Planning Application Ref: LY/15/21/PL

Location: Crossbush Service Station, Lyminster Road, Lyminster, BN17 7QQ

Description of works: Erection of a drive-thru coffee shop (Use Class E) with associated infrastructure. This application is in CIL Zone 3 (zero rated) as other development. This application is a Departure from the Development Plan

Drawings
Tree Protection Plan

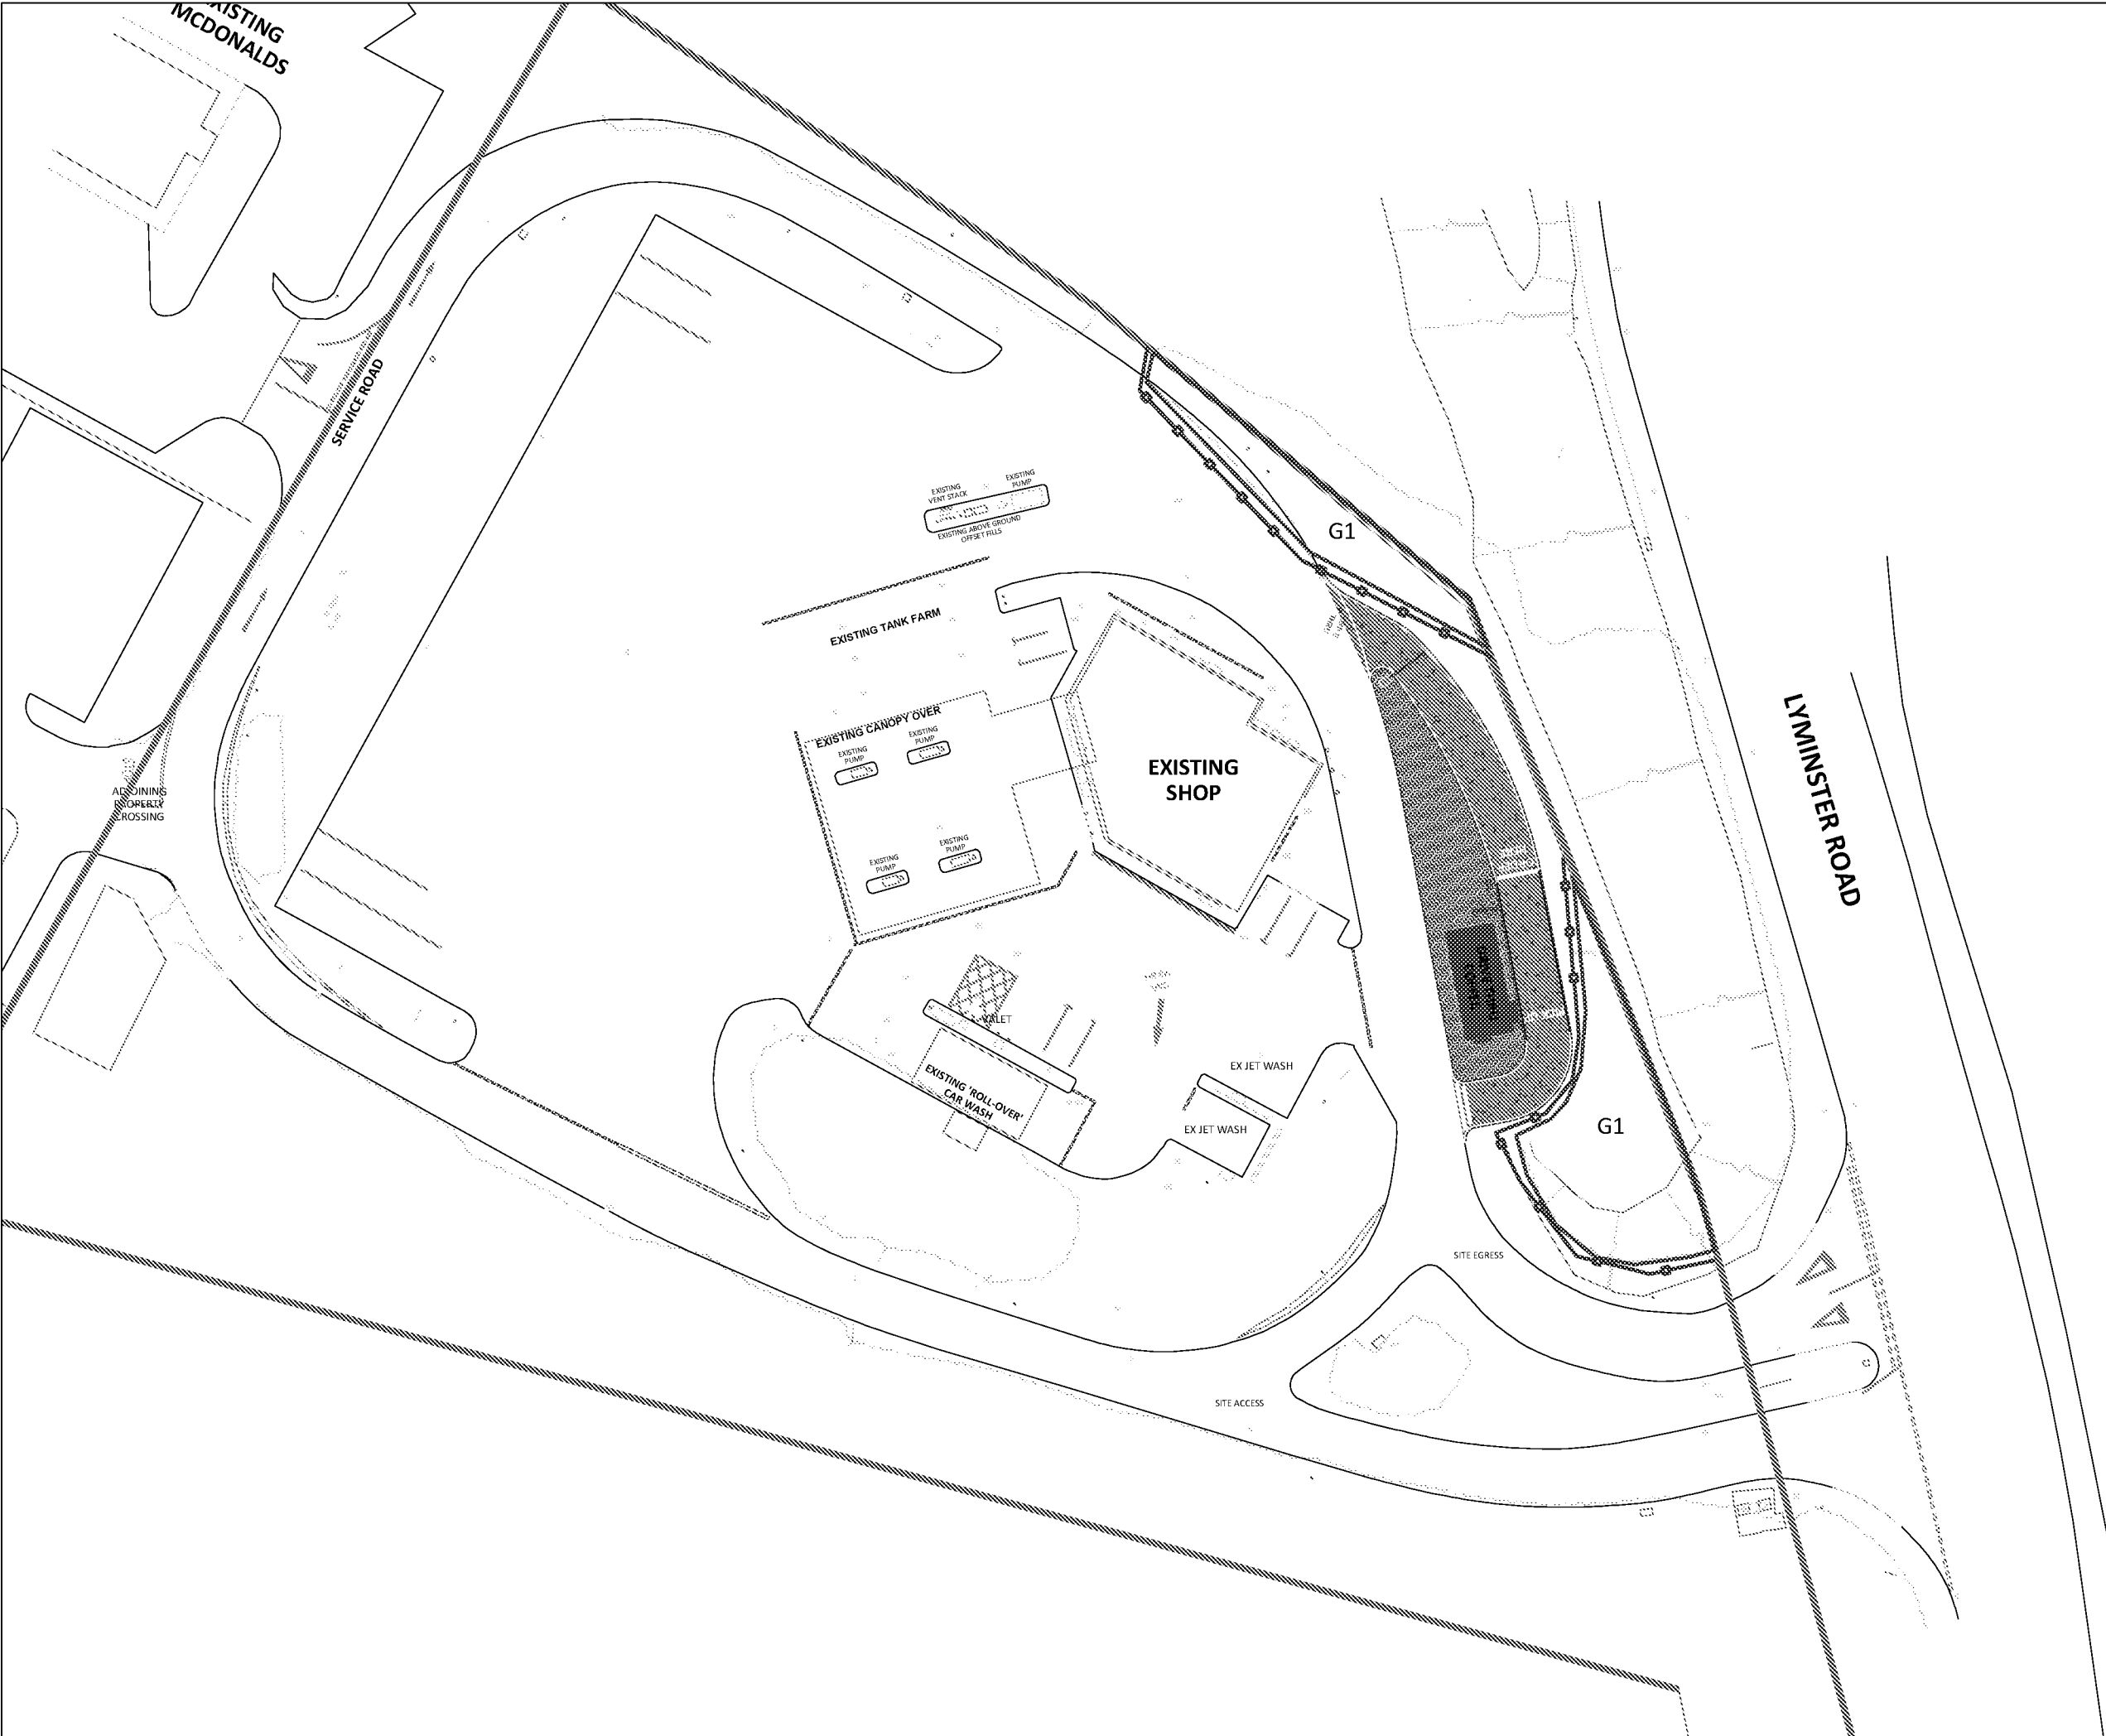
- If minded to approve this application, I recommend the following conditions be applied:
 1. Before the site is occupied or any machinery is introduced to the site or demolition work or construction work or alterations to existing ground levels takes place, written confirmation is required from the Arboricultural Expert representing the site owner(s), confirming that all protective fencing has been inspected and found to be 'Fit for Purpose' as required under British Standard 5837:2012 and been erected and positioned exactly as shown on the **Tree Protection Plan, DEP Landscape Architecture Ltd., dwg. no. 03, Revision x, 18.08.21**
